Rezoning Transportation Analysis

Petition Number: 2024-004

Date	Description
2-21-24	First Review (JP)
3-20-24	Second Review (JP)

RZ-1.0

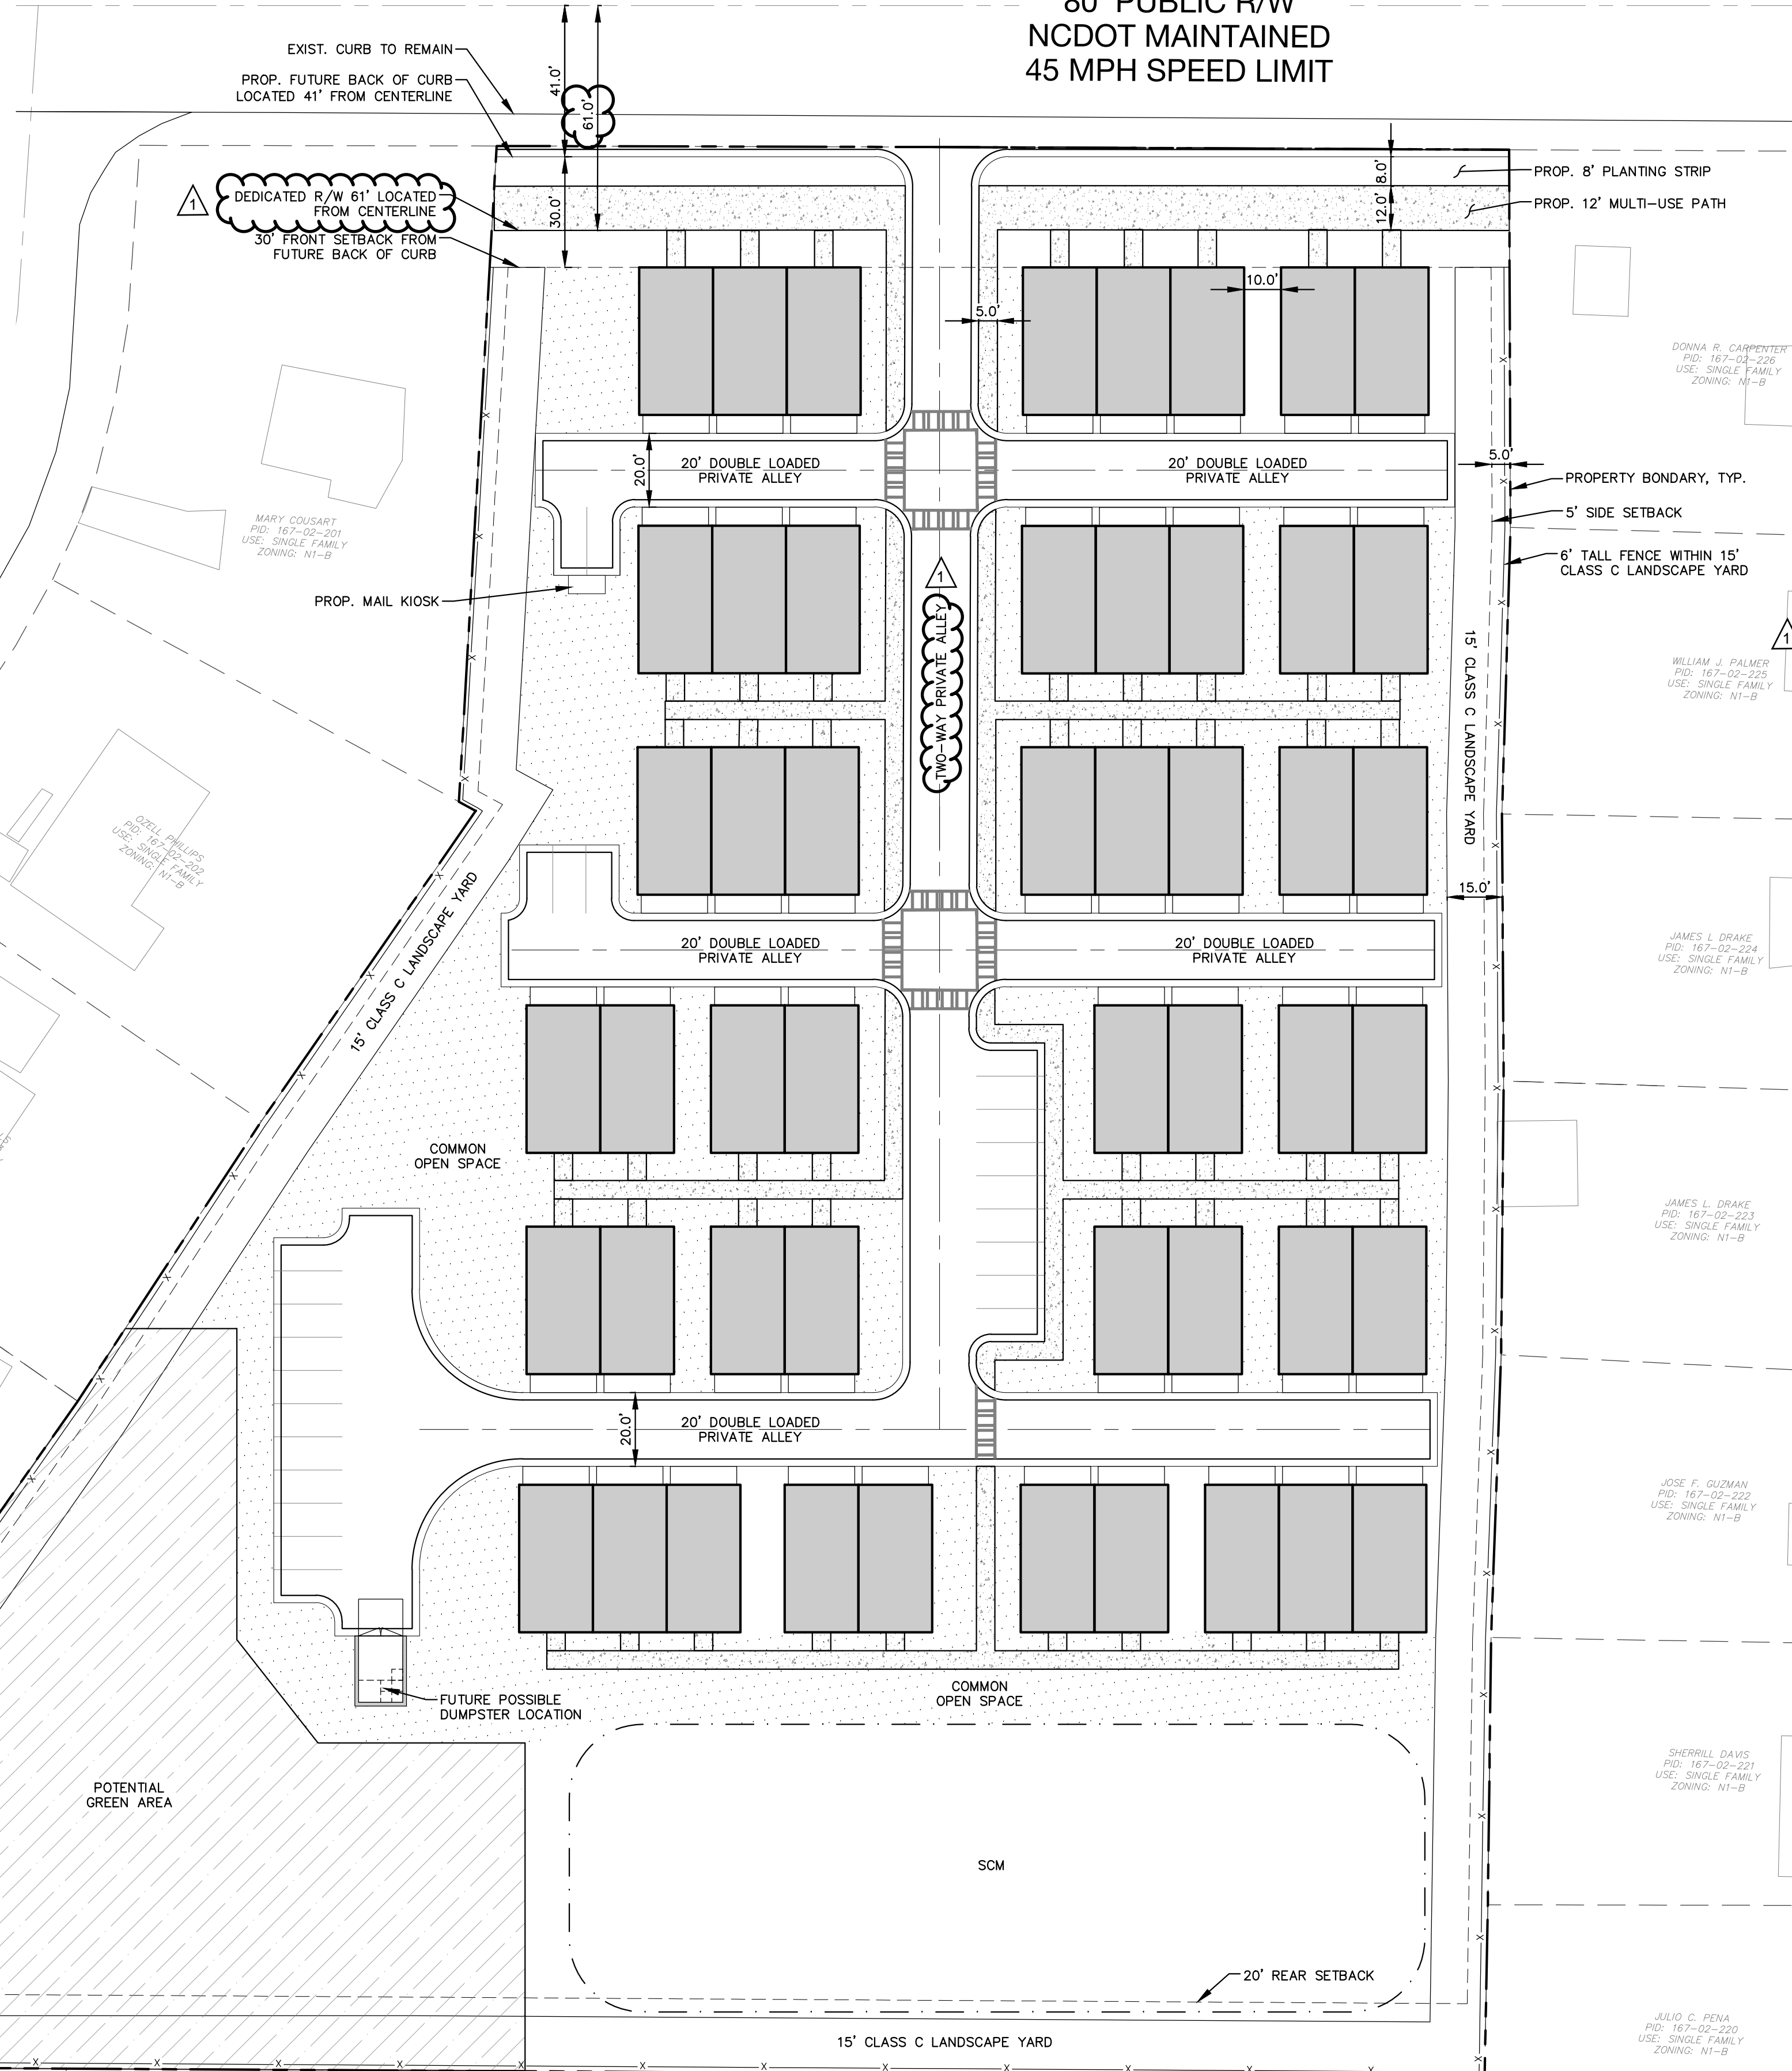
- 4. **Outstanding Comment 3.20.24:** In coordination with NCDOT, revise site plan and conditional notes to install a right turn lane into the site with 50' of storage.

5. Revise site plan to show the curb and gutter at the existing location. Due to the length of the sites frontage to South Tryon Street, the curb and gutter does not need to be relocated. Continue to show the future back of curb at its future location. Streetscape will be installed off of the future back of curb as shown.

Clarifying Comment 3.20.24: Just use one line to show future back of curb. Move the driveway cut and curb and gutter to the existing location.
